Further to our previous email responding to the conservation officers comments on Mill Cottage - I attach a detail of window shutters in flint walls. We are not yet able to confirm the stone paving spec for the external terrace and ask that this may be a condition prior to commencement of this part of work only along with the sample panel of new garden wall.

We have read through Martyn White's (Conservation officer) comments on Mill Cottage applications CM/38/19/PL and CM/39/19/L which are very useful and encouraging and we would like to confirm and respond as follows:

Mill Cottage:

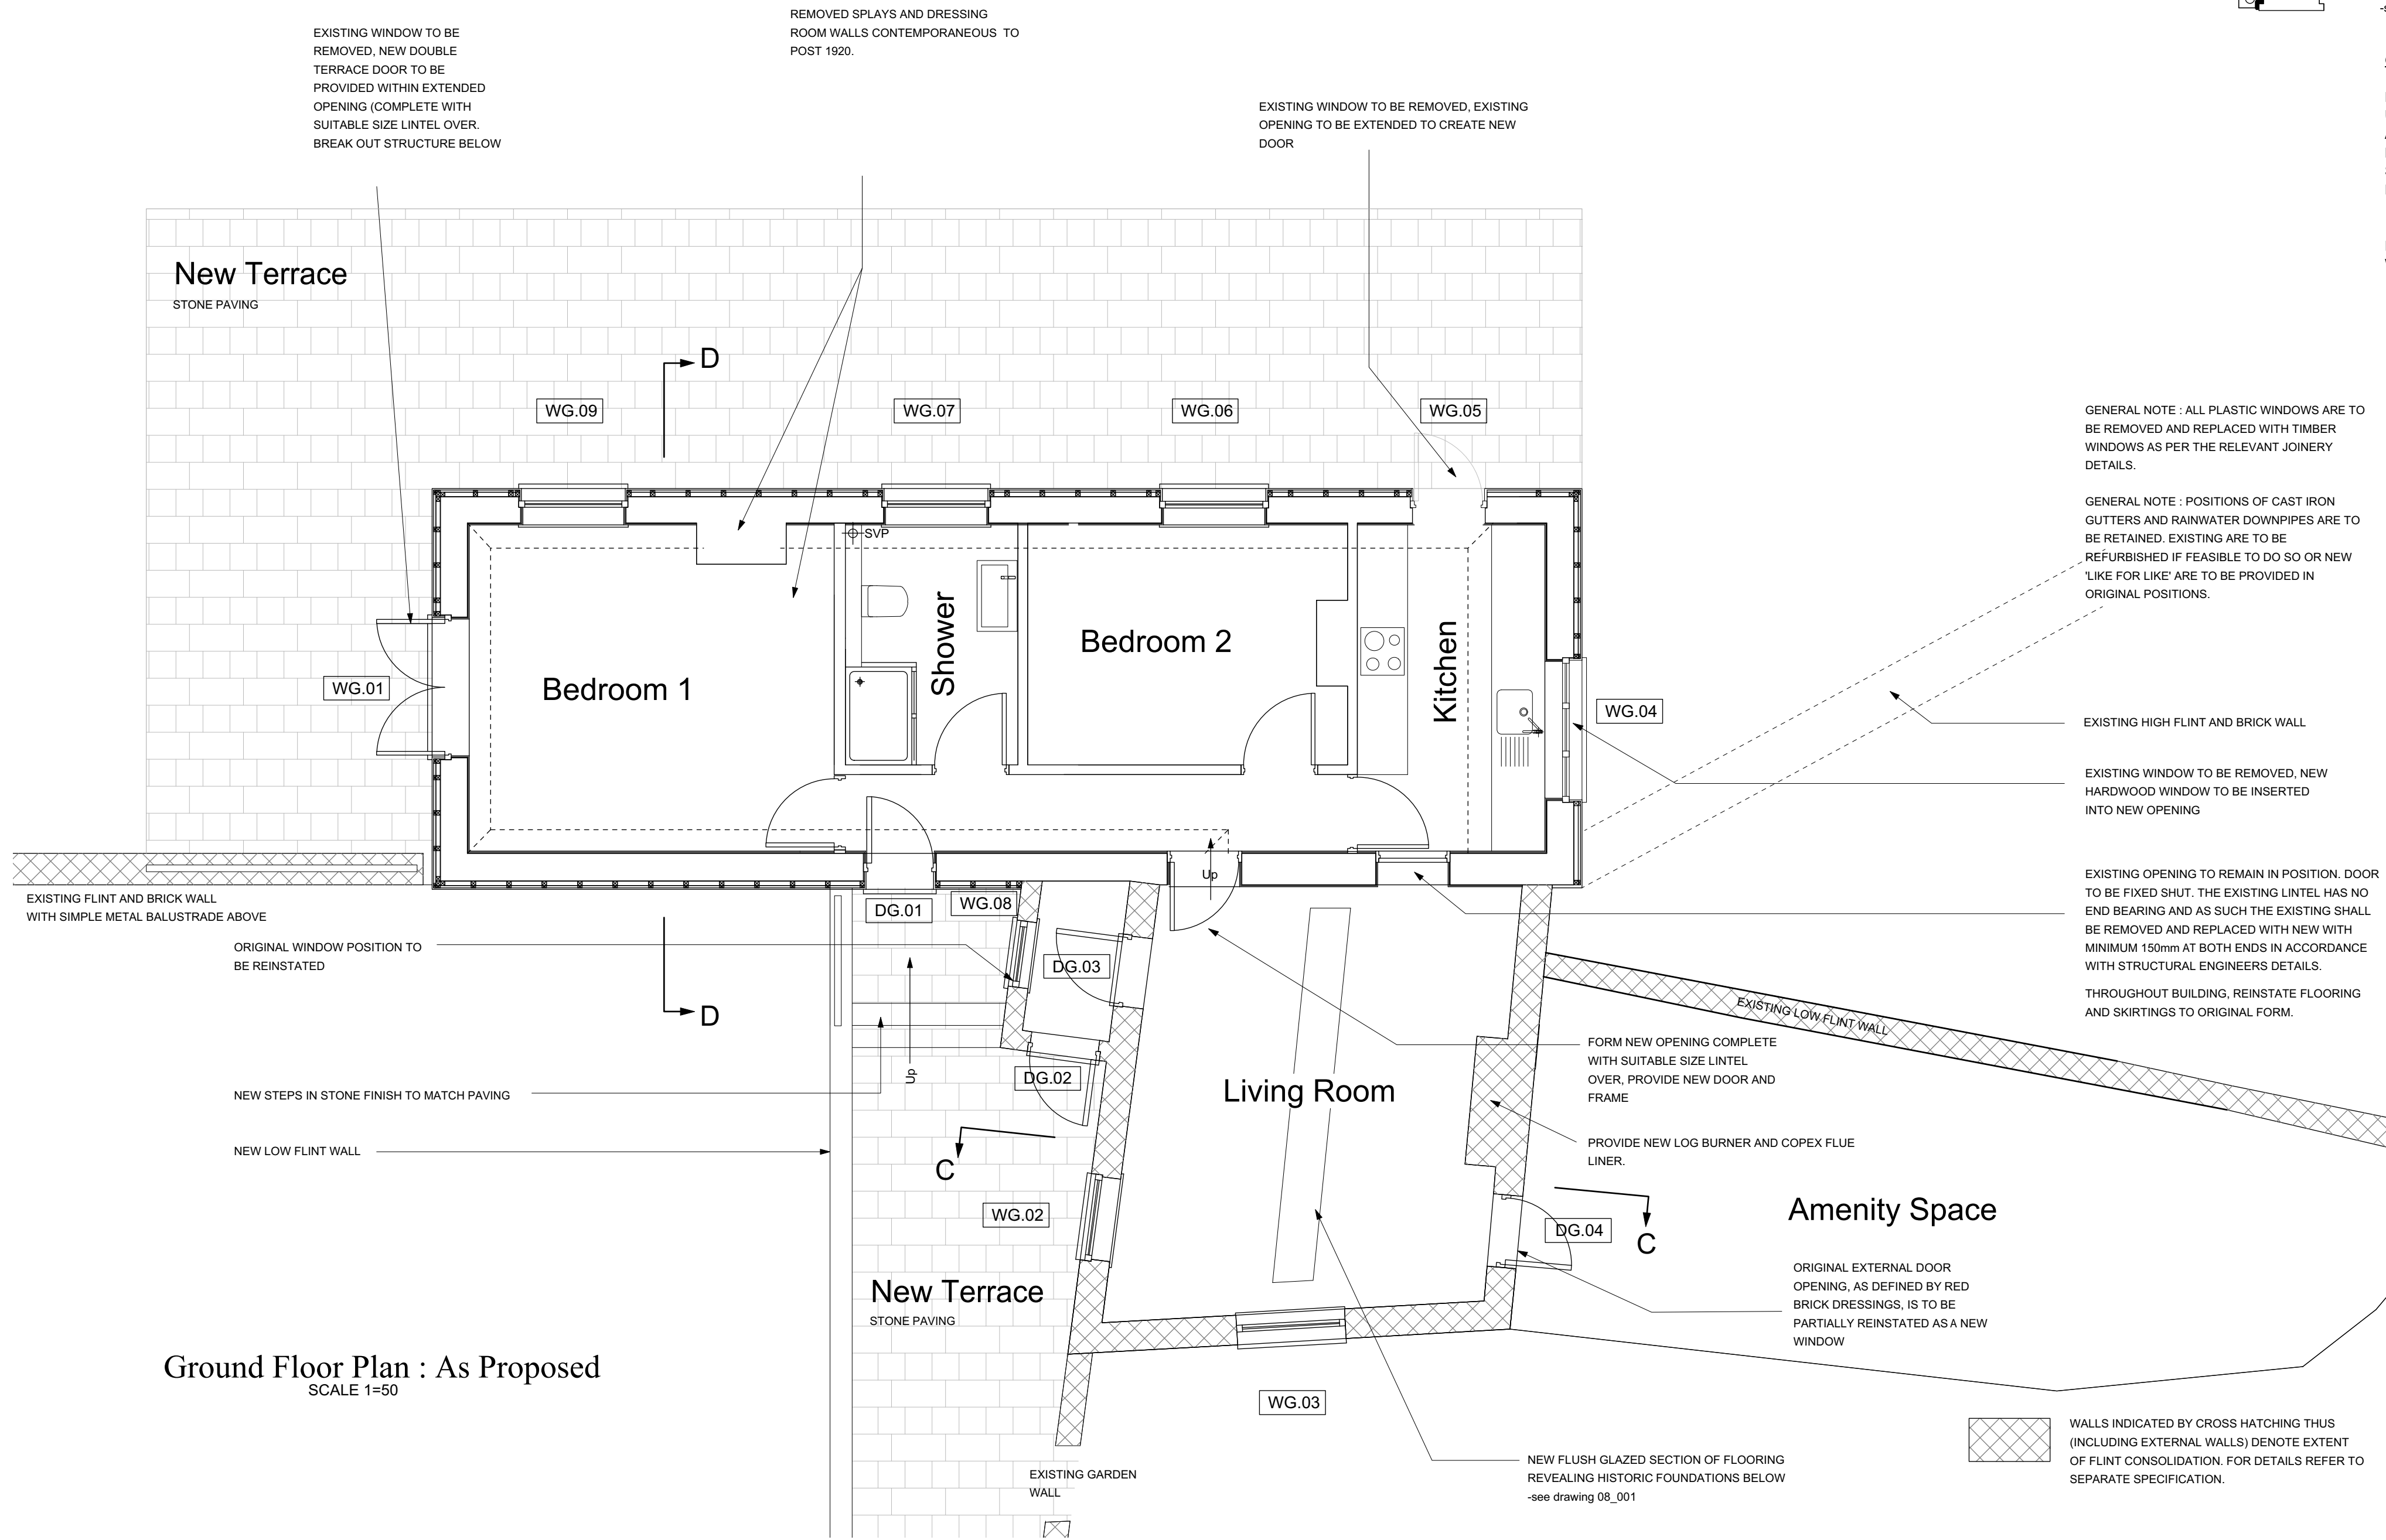
- Shutters detail to windows in flint walls
- Detail of stone paving specification on external terrace
-

- We can provide a sample panel of new walling to front terrace - can this be a condition prior to commencement of this part of work only?

- Internal flooring - we confirm the floors are replacement concrete slab with polished concrete screed finish.
- We can confirm the balustrade will be painted not sprayed.
-
